## CITY OF ALBUQUERQUE

1400 San Mateo Building 1400 San Mateo Blvd SE Traffic Circulation Layout

Architect's Stamp dated 11-02-16 (L18D081)

October 5, 2016

SHT. INFO.
PARKING LAYOUT
A10 OF 14

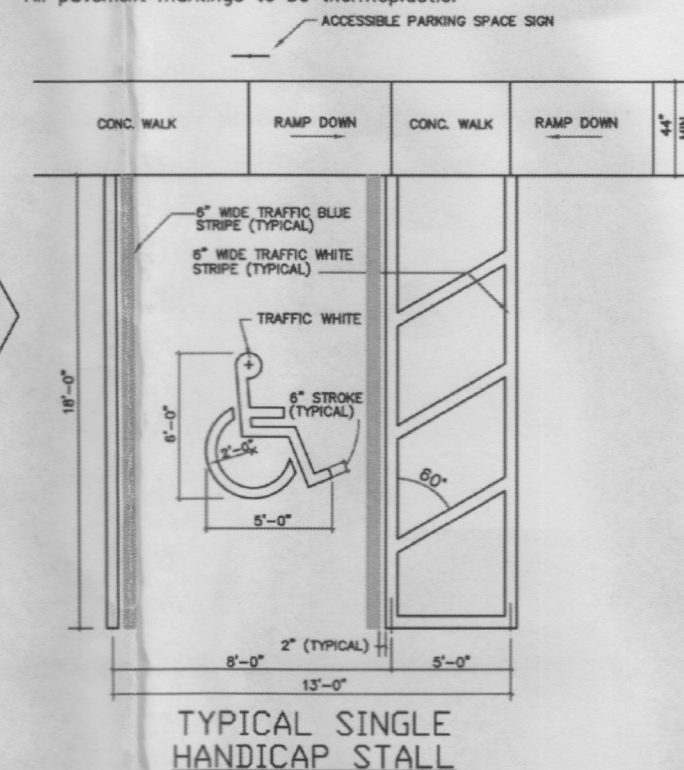
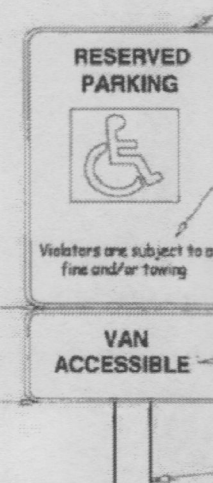
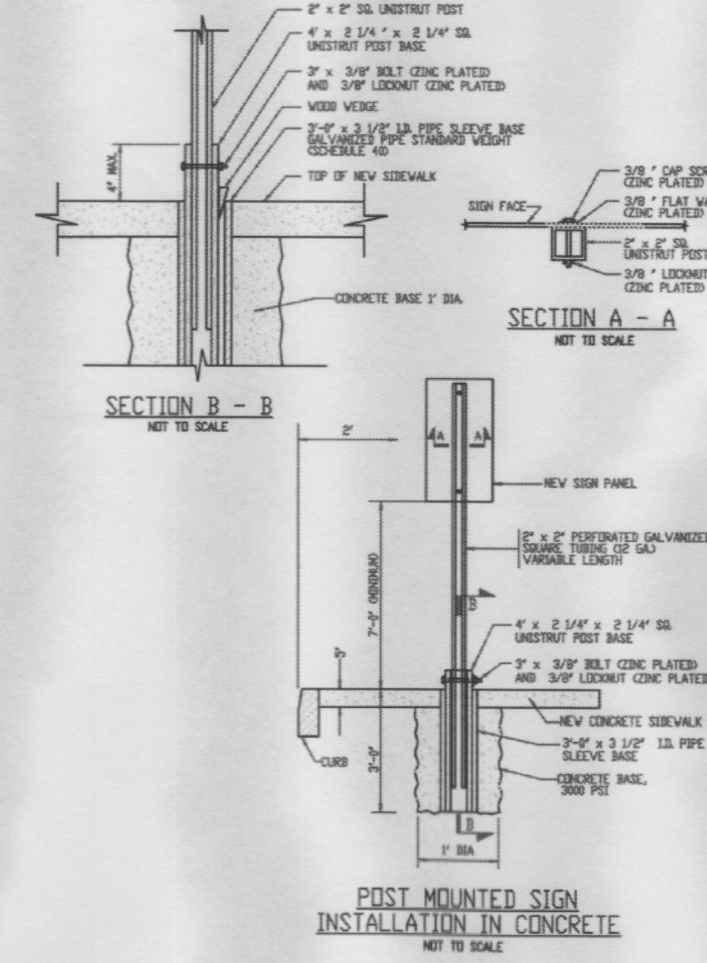
Per the zoning code, a 6 ft. wide ADA accessible pedestrian pathway is required from the public sidewalk to the building entrances. Please clearly show this pathway and provide details.

One-way vehicular paths require pavement directional signage and a posted "Do Not Enter" sign at the point of egress. Please show detail and location of posted signs.

Call out all existing and proposed access drives. Please identify any existing access drives that will be modified. Unused curb cuts must be replaced with sidewalk and curb & gutter. A build note must be provided referring to the appropriate City Standard drawing.

- 8. Please provide a sight distance exhibit
- 9. Show the clear sight triangle and add the following note to the plan: "Landscaping and signage will not interfere with clear sight requirements. Therefore, signs, walls, trees, and shrubbery between 3 and 8 feet tall (as measured from the gutter pan) will not be acceptable in the clear sight triangle.
- 10. Please specify the City Standard Drawing Number when applicable.

- 11. Add a note stating "All broken or cracked sidewalk must be replaced with sidewalk and curb & gutter." A build note must be provided referring to the appropriate City Standard drawing.
- 12. Please include two copies and a PDF copy of the traffic circulation layout at the next submittal.

A10 of 14

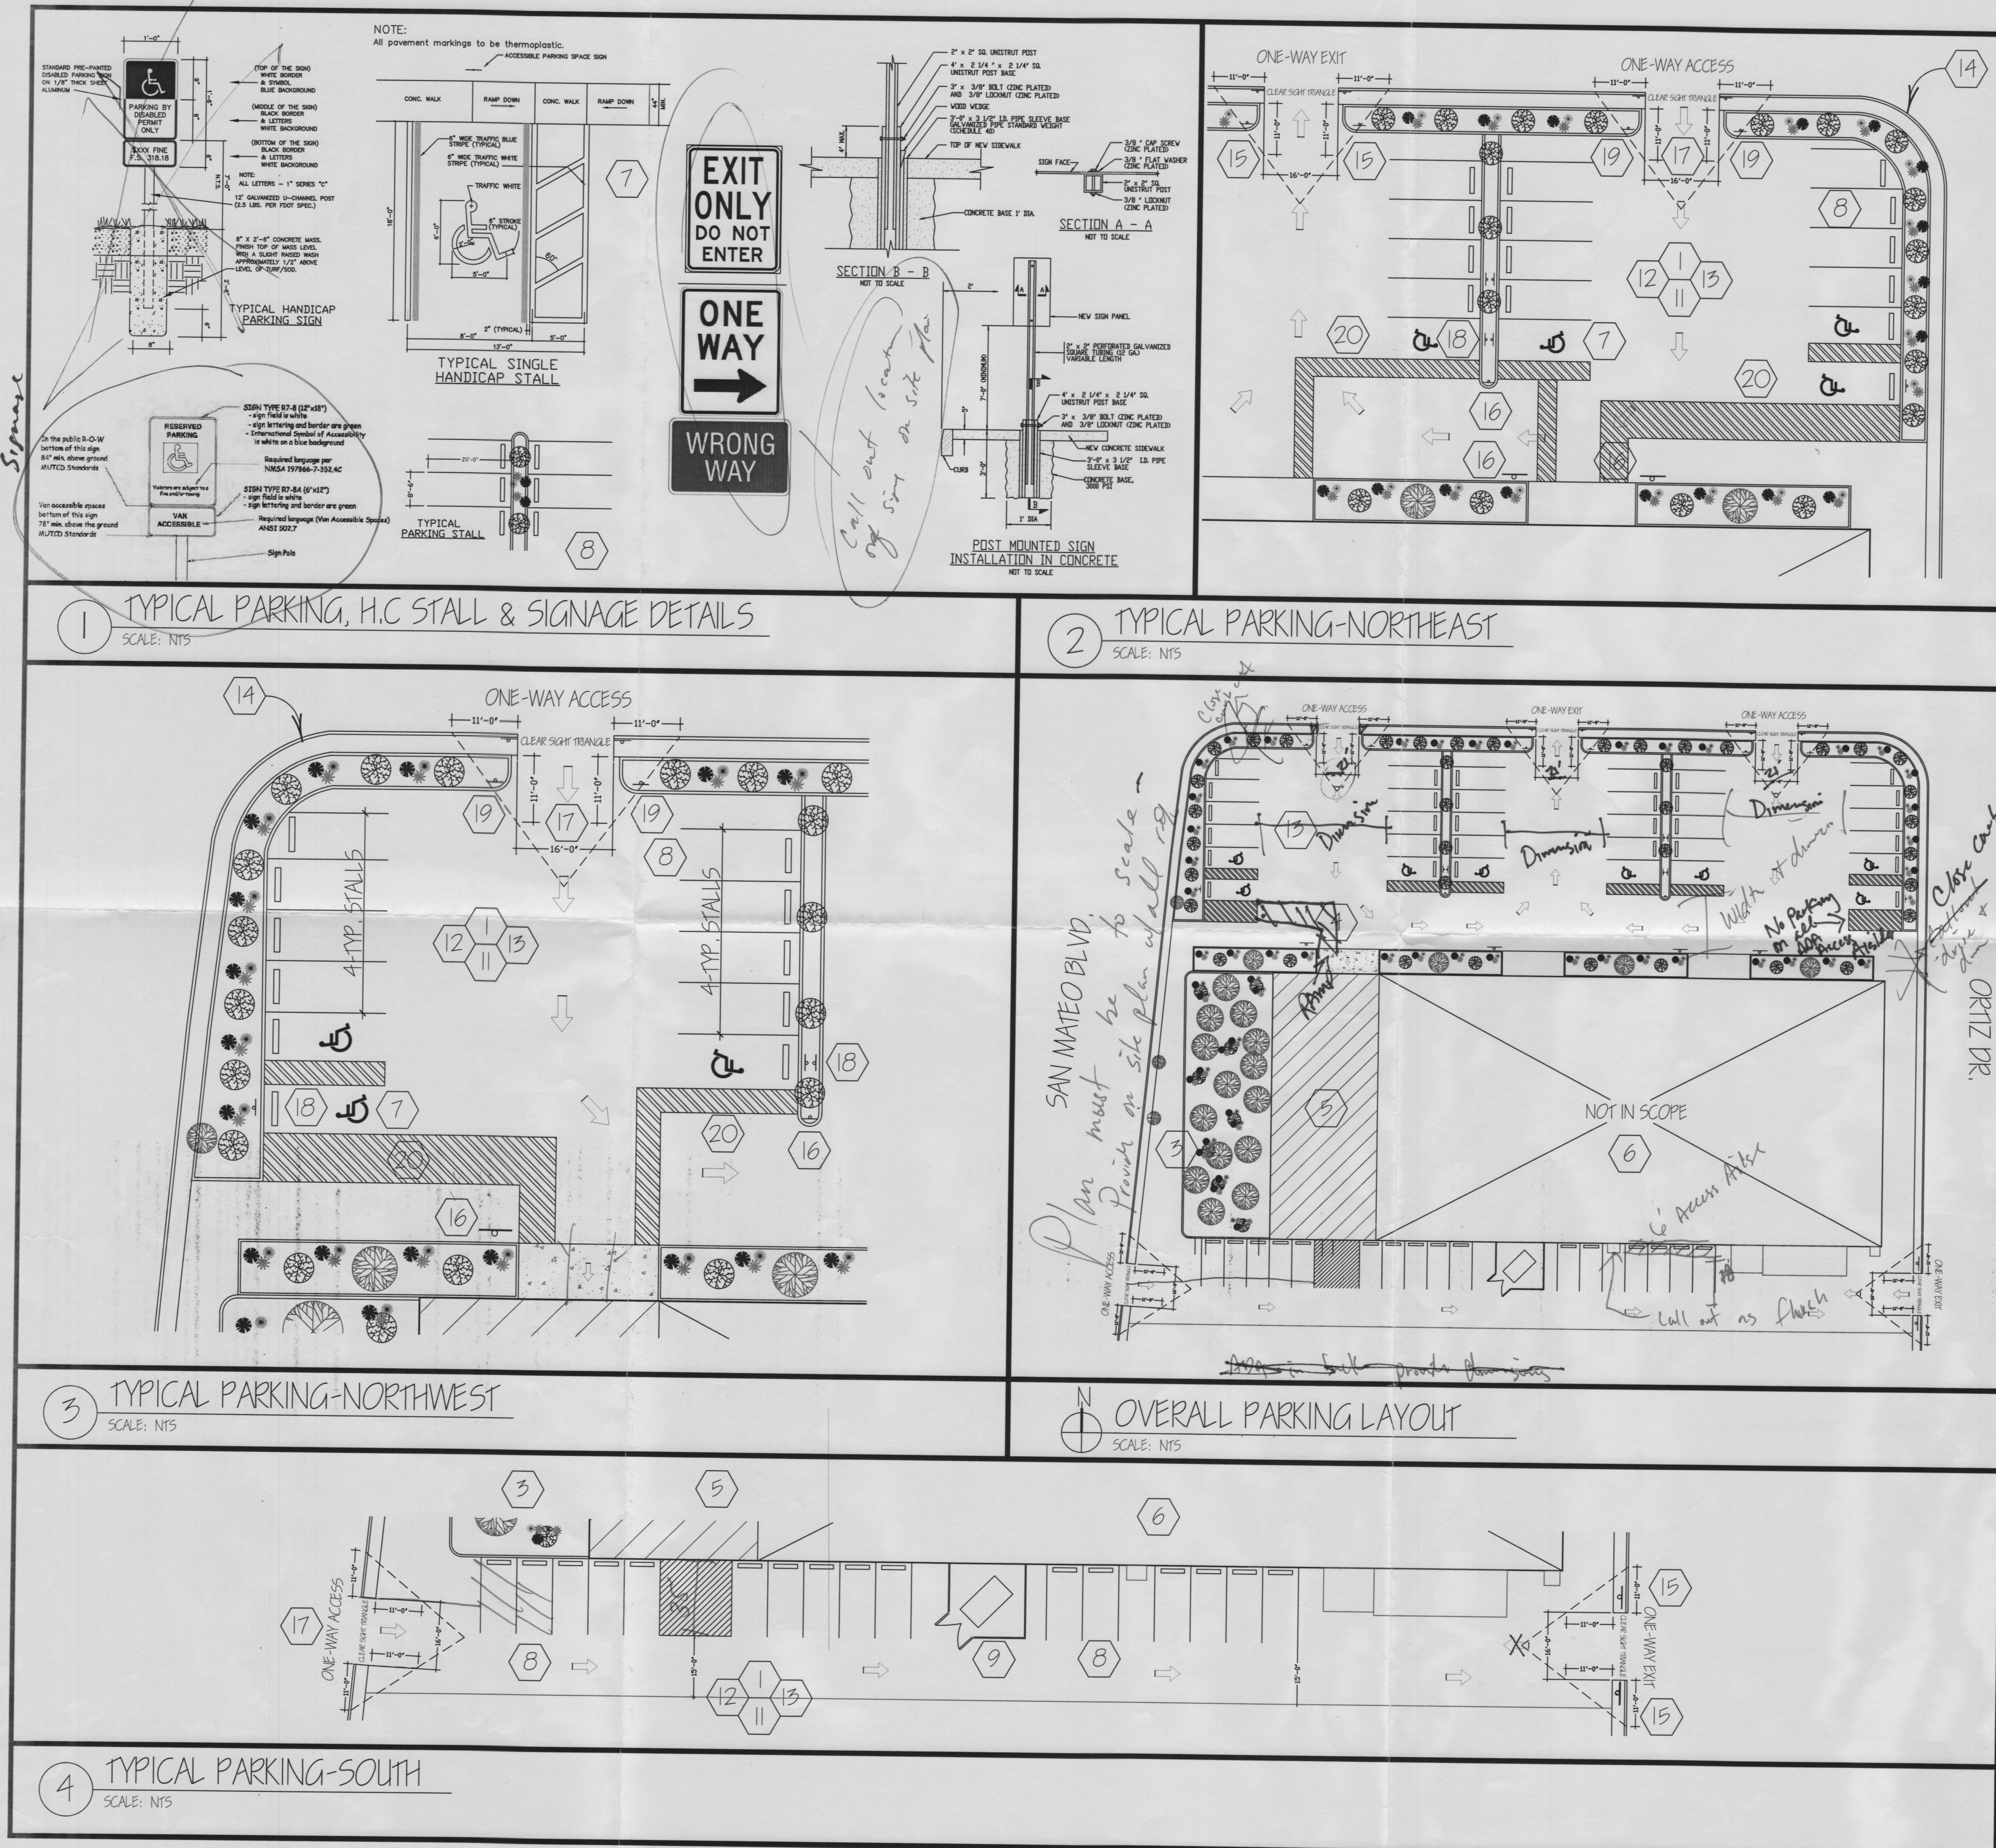
- 1. Please review and revise plan to provide all information listed on the attached Traffic Circulation Layout checklist.
- 2. Please refer to the attached Accessible Parking Checklist and revise the plan accordingly.

Minimum drive access drive aisle width must be a minimum of 24 feet for two way traffic. Any width less than 24 feet must be one-way access only.
